EXTRACTS FOR DPI-WATER

2.	RESPONSES TO ISSUES RAISED ABOUT THE AMENDED PROJECT	2
2.16	GROUNDWATER	2
2.16.4	Groundwater Controls	2
2.16.7	Licencing	4
2.29	SURFACE WATER.....	11
2.29.1	General.....	11
2.29.2	Downstream Flows	13
2.29.4	Saline Water Treatment, Use and Salt Disposal.....	16
2.29.7	Surface Water Controls	20
2.29.12	Final Landform.....	36

2. RESPONSES TO ISSUES RAISED ABOUT THE AMENDED PROJECT

Figure 2.16 displays the conceptual process flow diagram for the plant. An overview of the treatment steps is as follows.

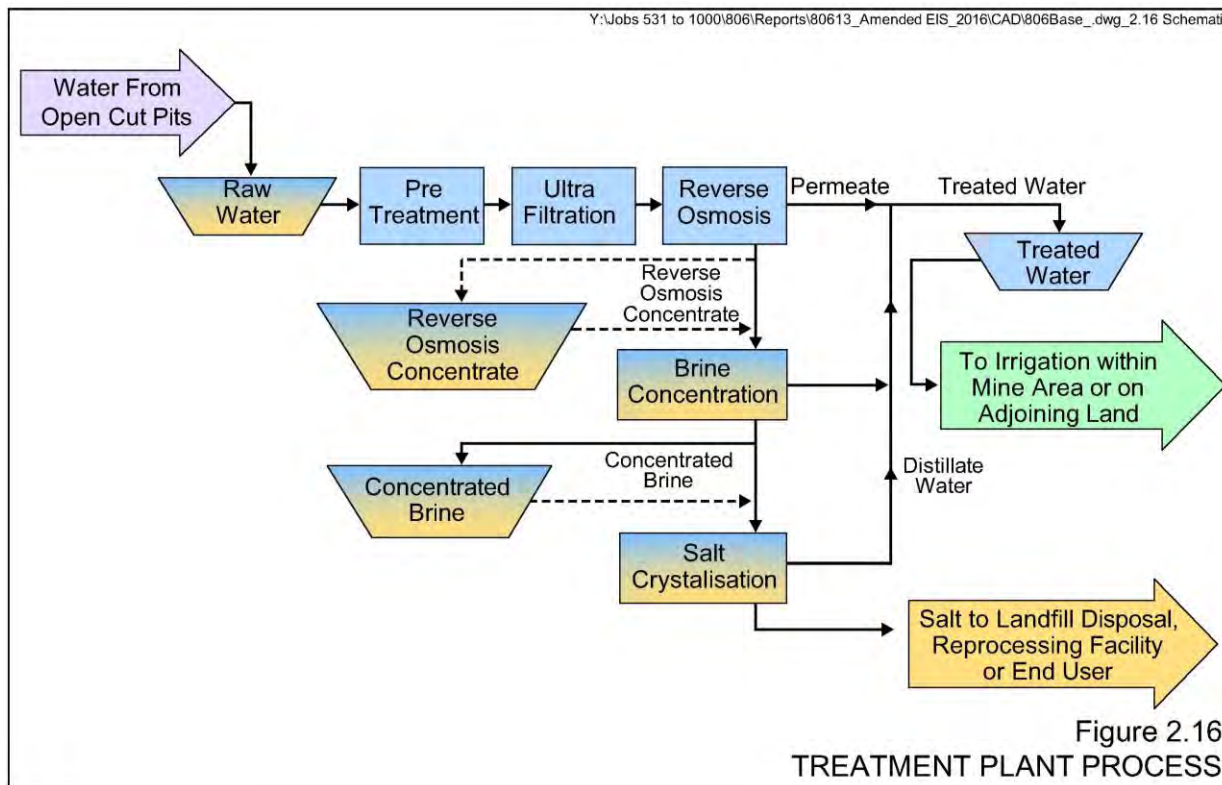
The proponent should provide further detail on the water treatment processes proposed for the water treatment plant to be installed in year 4 of the project, and the quality of treated water compared to water in the Avon River. This detail should outline why releases are only proposed for high flow conditions, with reference to the reduced water flow outlined above.

Based on the mine water balance for the amended Project, it was determined that a water treatment plant would be required in Year 4 of mining operations and beyond. The water balance, which was derived using the predicted groundwater and surface water inflows and losses from the system, e.g. by evaporation or dust suppression use, identified that a 2.5ML capacity treatment plant would most likely be appropriate, but noted that the plant throughput required would be confirmed through monitoring of the saline water zone during the early stages of mine development. This monitoring would involve both volumes and quality and the associated validation of the modelled predictions. The outcomes of these programs, and required permeate quality would be used in the detailed design of the water treatment components.
